Thanet Extension Offshore Wind Farm

Annex A to Appendix 6 to Deadline 7 Submission:
Log of Changes to the draft Development
Consent Order

Date: June 2019

Revision G

Onshore Street Work Plans - Sheet 1 of 2

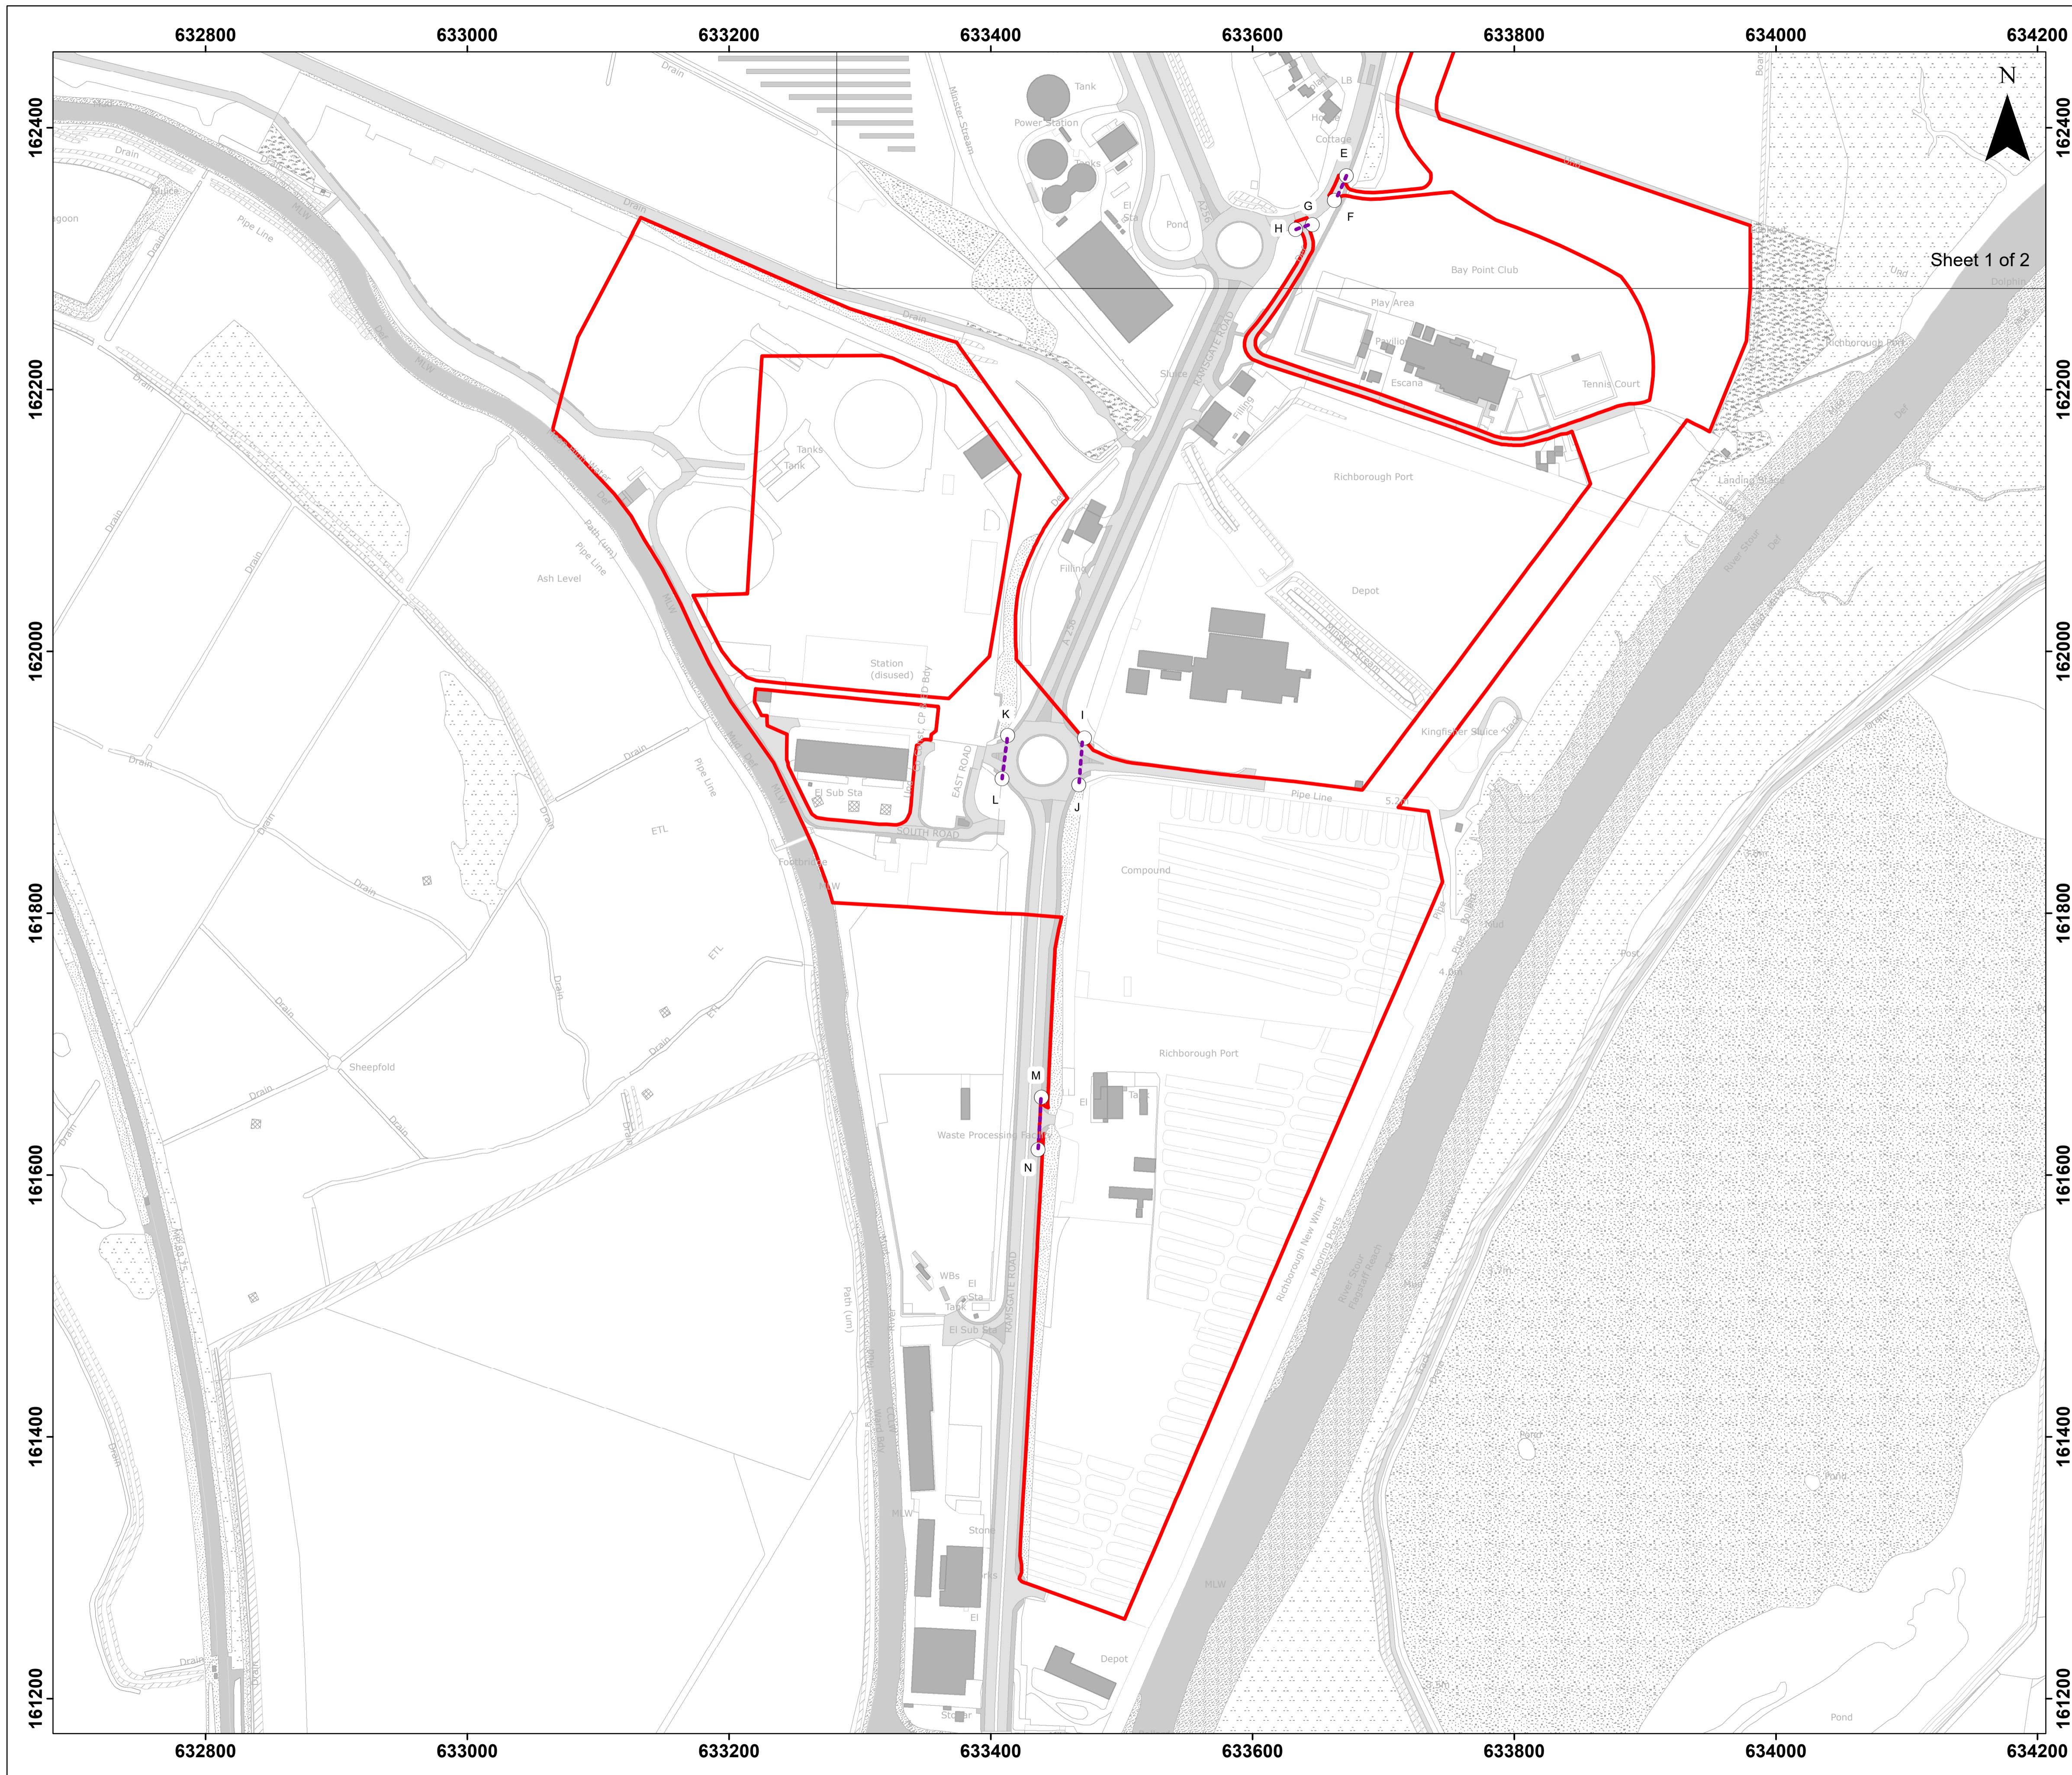
Ref	DCO Ref.	Rationale for change	Change made	DCO Version
1.	Schedule 2	In their Section 51 advice issued to the Applicant, the Planning Inspectorate noted that: "In relation to the dDCO Schedule 2, the dDCO refers to the works plans. This should be the onshore street works plans."	The wording has been amended throughout Schedule 2, for example – <i>SANDWICH ROAD at reference point A-B on the <u>onshore street</u> works plan</i>	2
